Our Ref: R/176/19/NMA

**Section 96A of the Town & Country Planning Act 1990 (as amended)
Town and Country Planning (Development Management Procedure) (England) Order 2015 (as amended) - Article 10**

Non-material amendment following the grant of reference R/141/18/PL to replace specified roof tiles.
West Hayne 19 Angmering Lane Rustington BN16 2TA

DRAWING No. 17207- 011

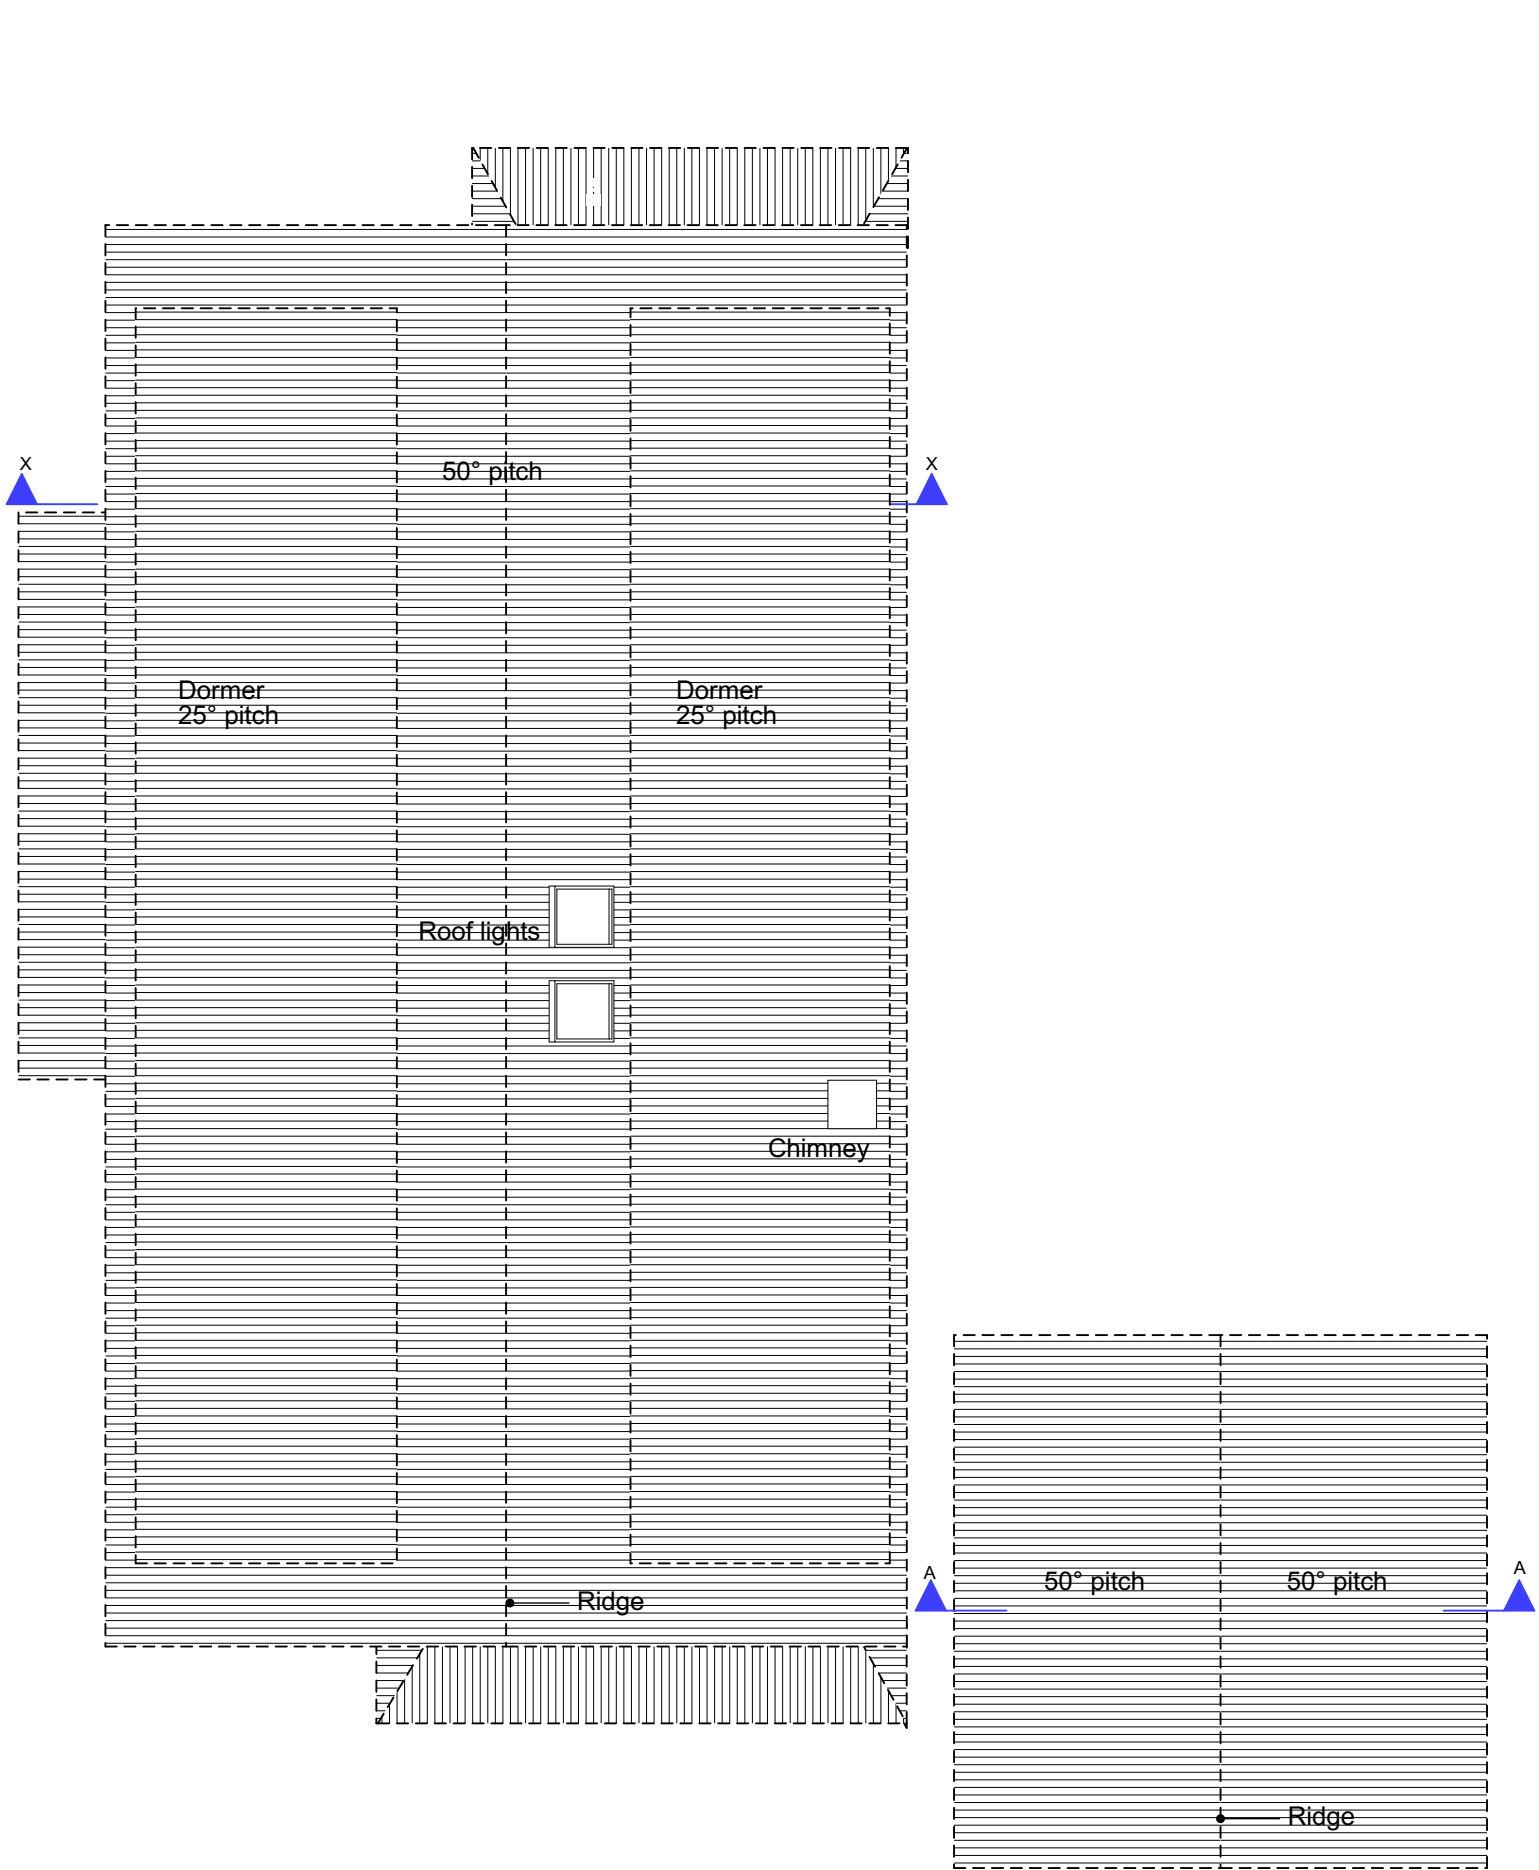
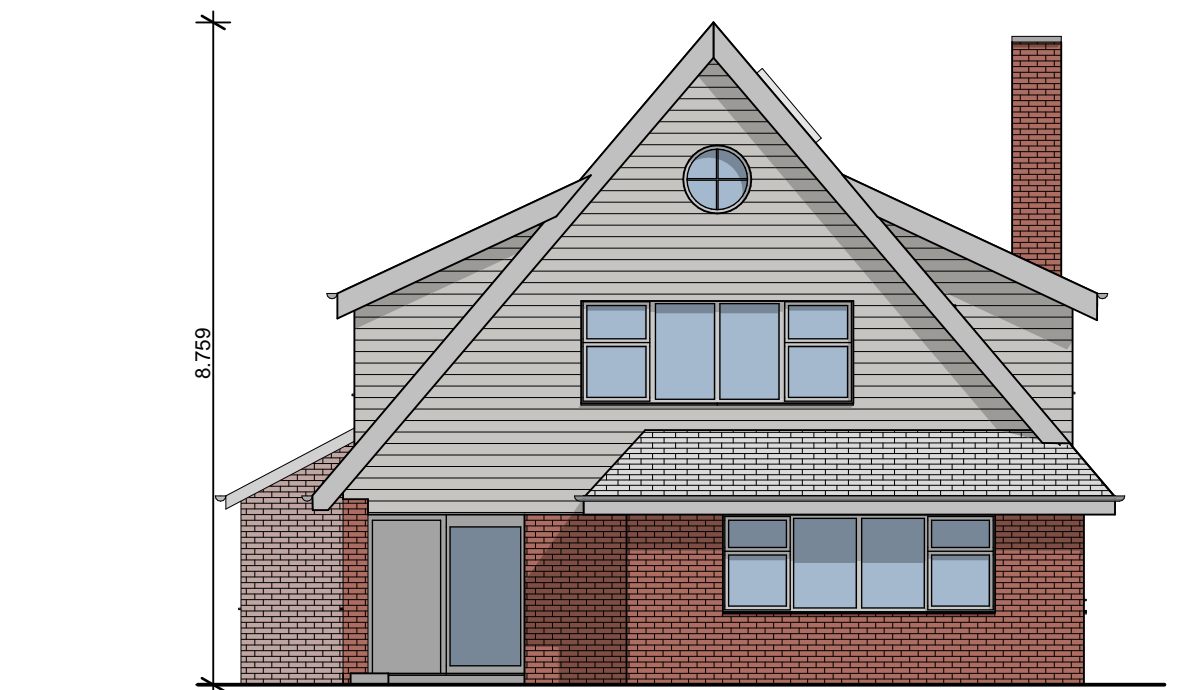
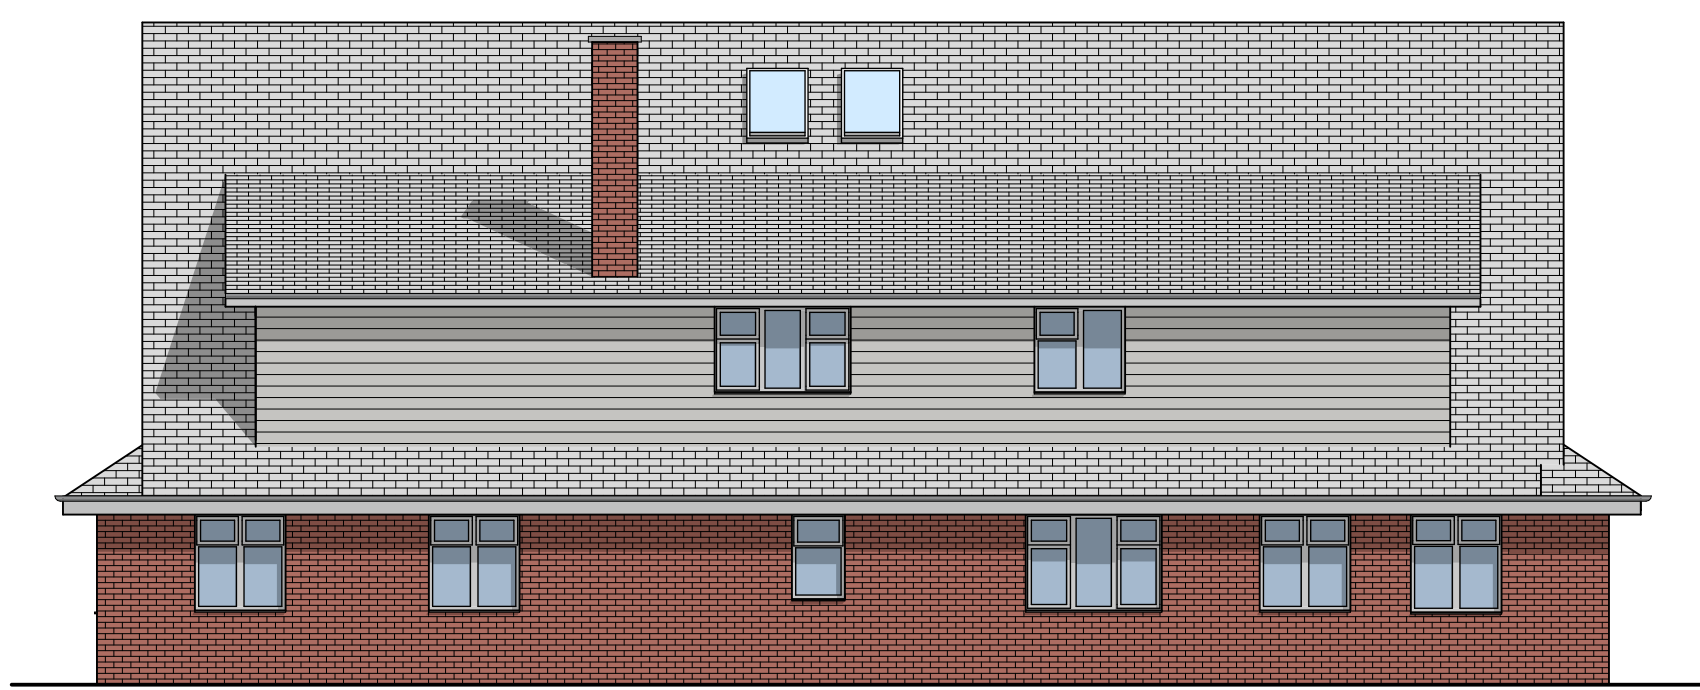
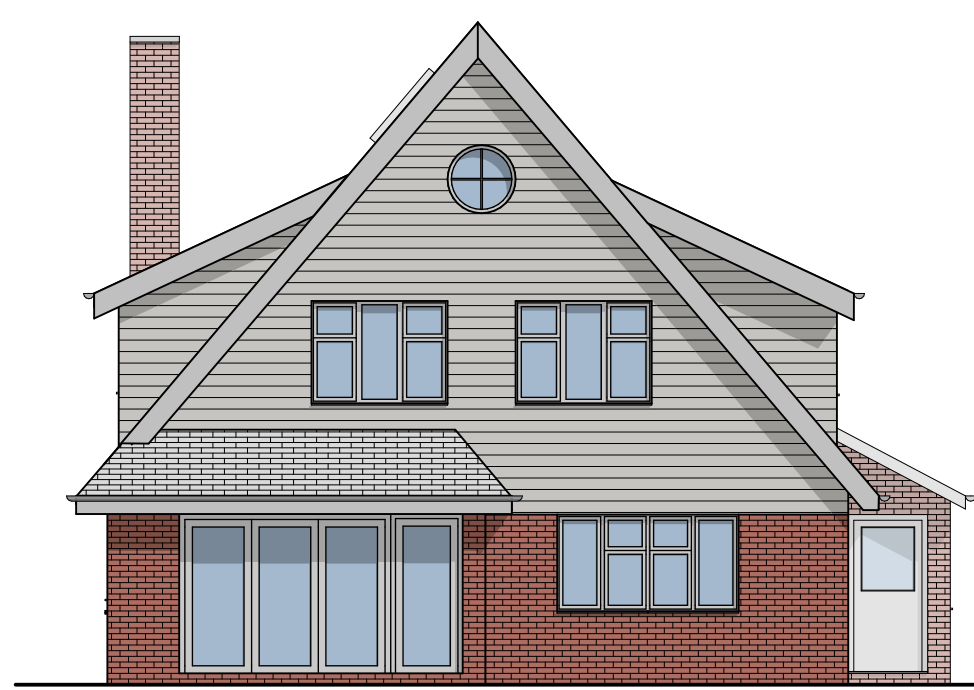
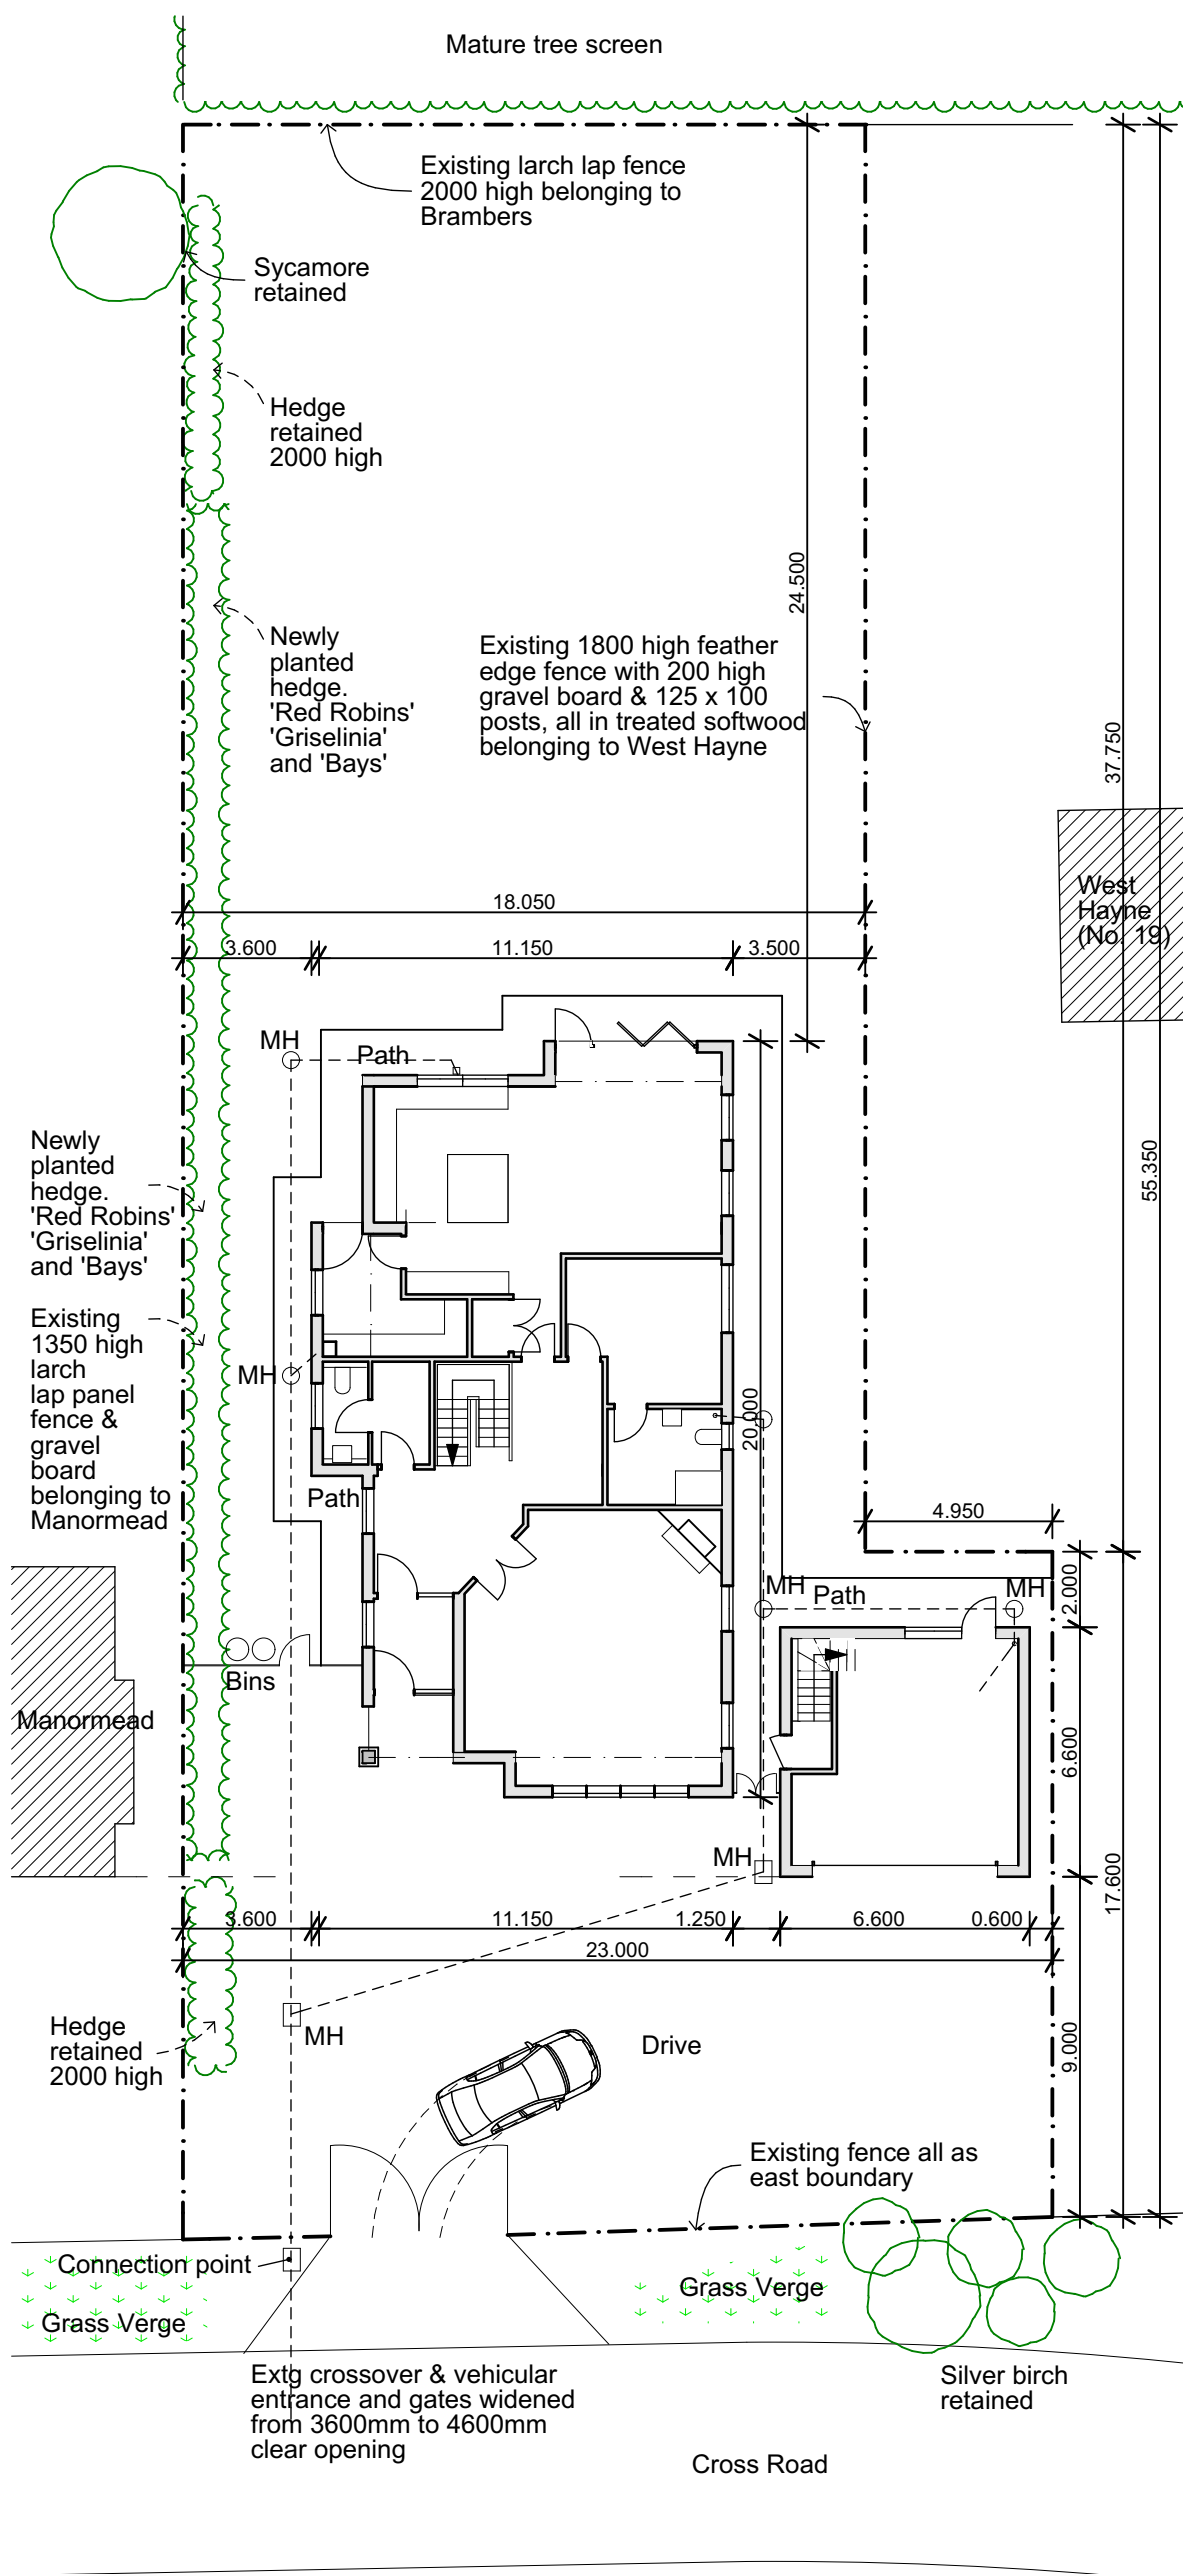
From the information submitted I am able to take the alterations detailed namely the change in roof tiles to Cembrit Jutland, straight edge, smooth surface fibre cement slate in blue/black as a Non-Material Amendment to R/141/18/PL. Drawing number 17207- 01I has therefore become the approved plan for planning permission R/141/18/PL.
